STATE OF NORTH CAROLINA
DEPARTMENT OF TRANSPORTATION

Addendum No. 1

Dare County (F-5700)

Construct 183'-7" X 46' X 10'-6" Passenger/Vehicle Ferry

A

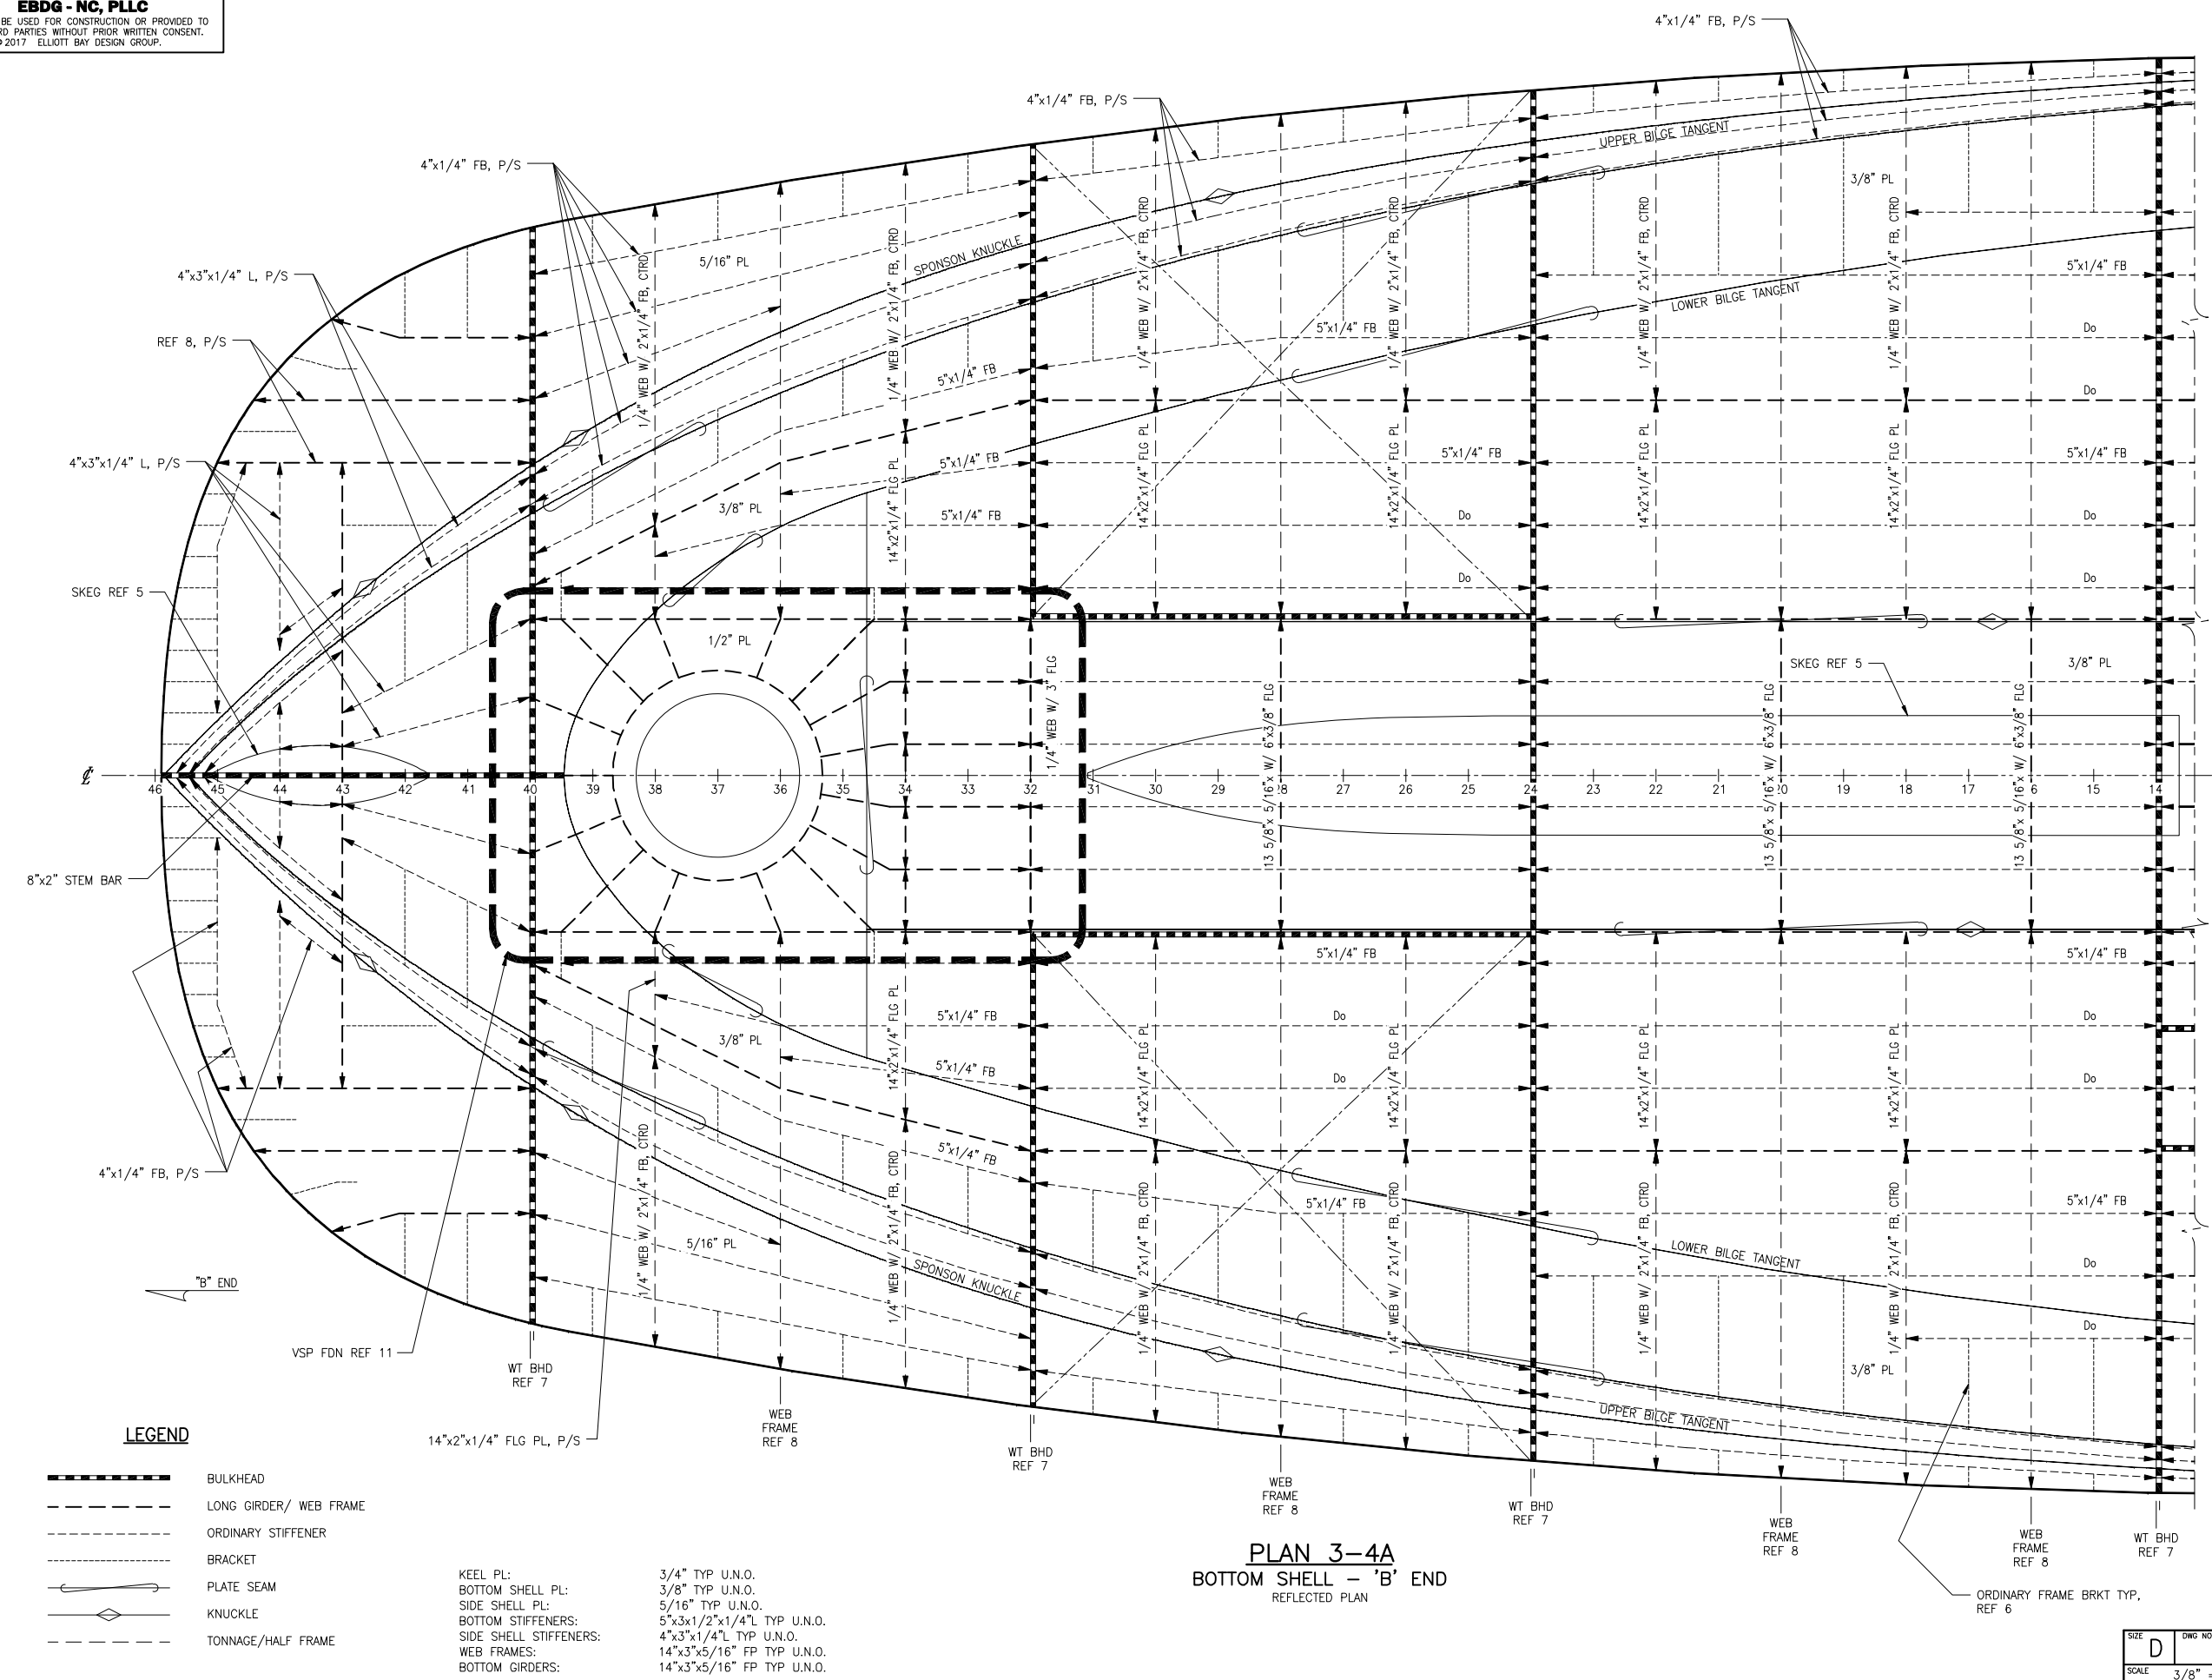
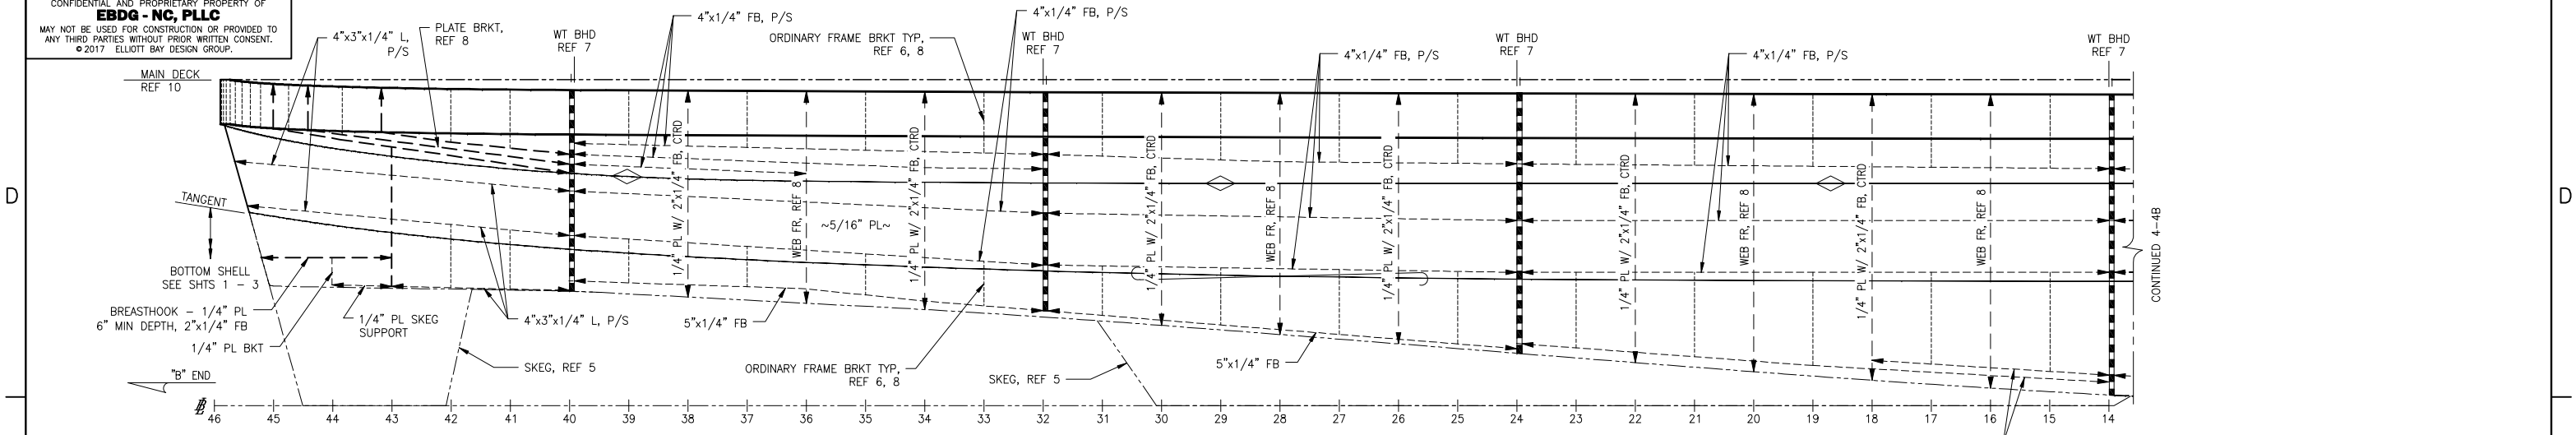
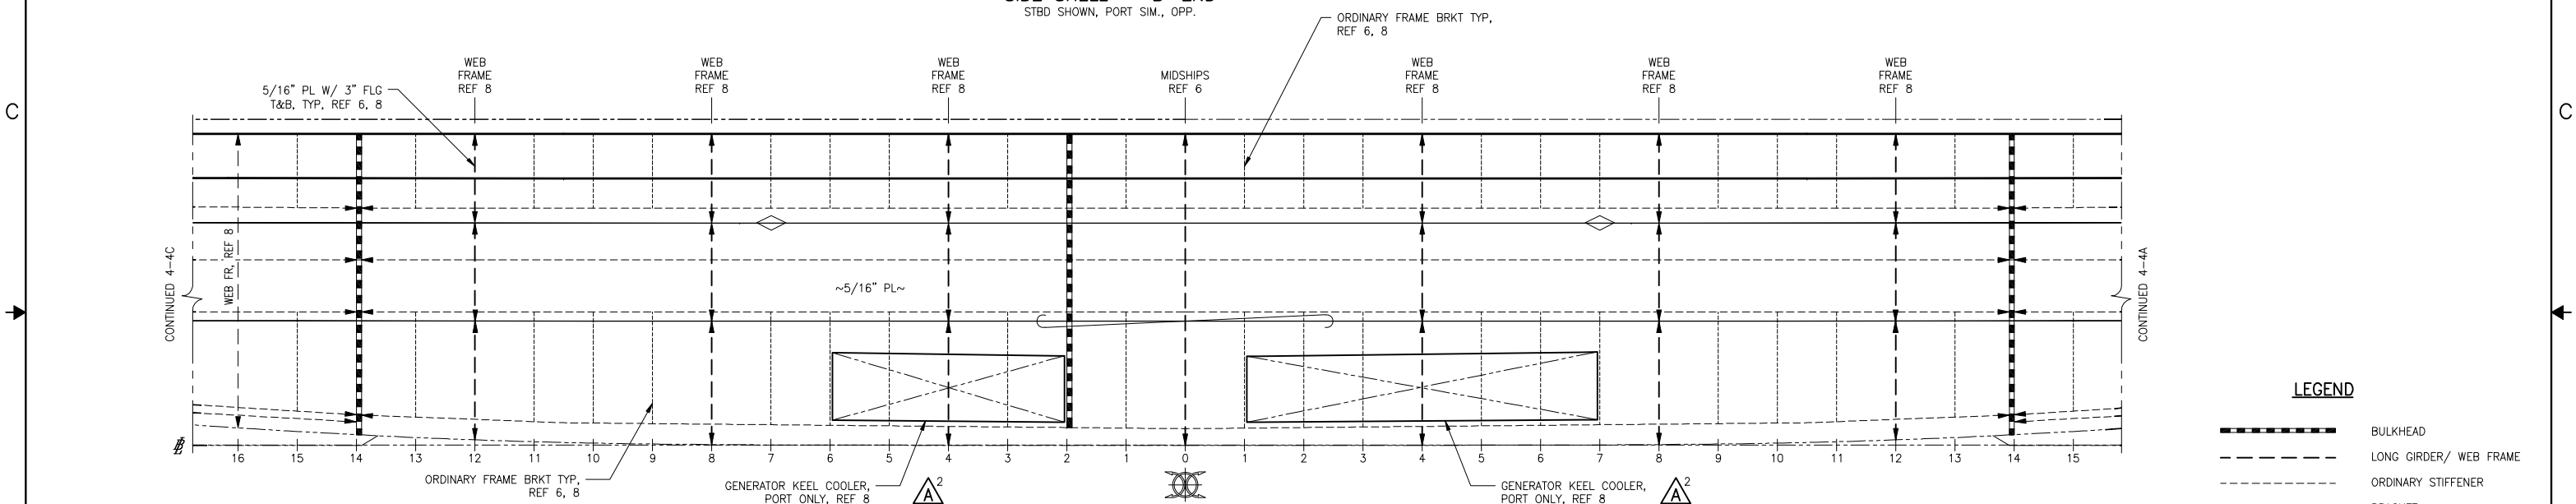
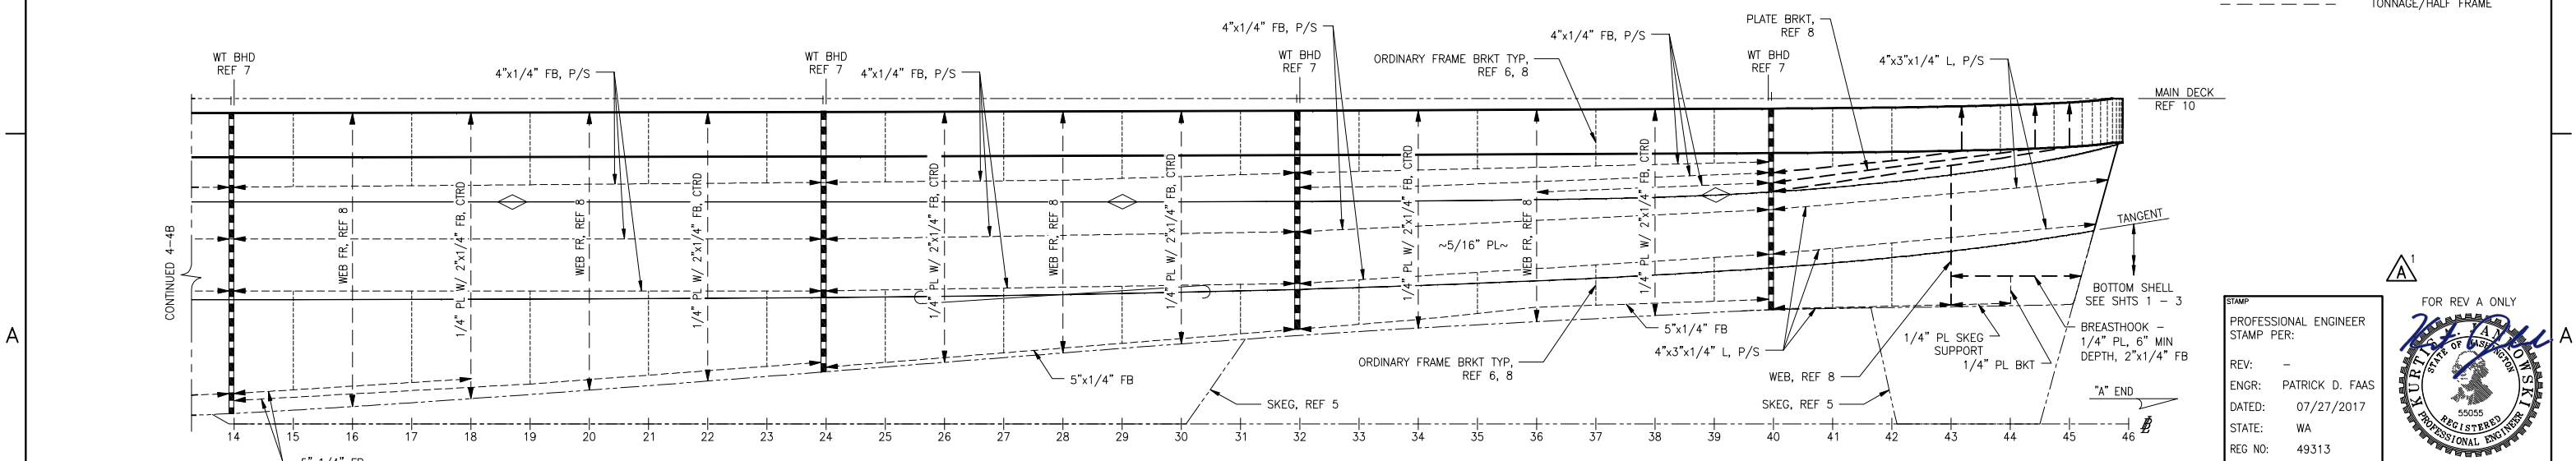
Sheet No.	Revisions
	Lines Plans
100-1: Sheet 1, Zone 2B	Removed 10' and 12' waterlines from body plan
100-1: Sheet 1, Zone 3B	Updated description of bilge tangents
100-1: Sheet 1, Zone 5B	Added transverse chine line to flat hull
100-1: Sheet 2, Zone 2A	Added thruster CL Frame 37 to shear plan
100-1: Sheet 2, Zone 2C	Added transverse chine line to flat hull
	Profiles and Deck Arrangements
101-1: Sheet 1, Zones 3B & 5B	Relocated masts to Frame 23
101-1: Sheet 2, Zone 3C	Added camber and tumblehome dimensions to midship section
101-1: Sheet 3	Updated chock and cleat locations in main deck plan; added hatches to main deck and hold plan views and added tank capacities to hold plan
101-1: Sheet 4, Zone 1D	Added grab-rail to pilot house console detail
101-1: Sheet 4, Zone 2D	Modified pilot chair location / size in pilot house console detail
	Bottom and Side Shell
110-1: Sheet 2, Zone 4D	Reversed position of keel coolers about midship

110-1: Sheet 4, Zone 4B	Reversed position of keel coolers about midship
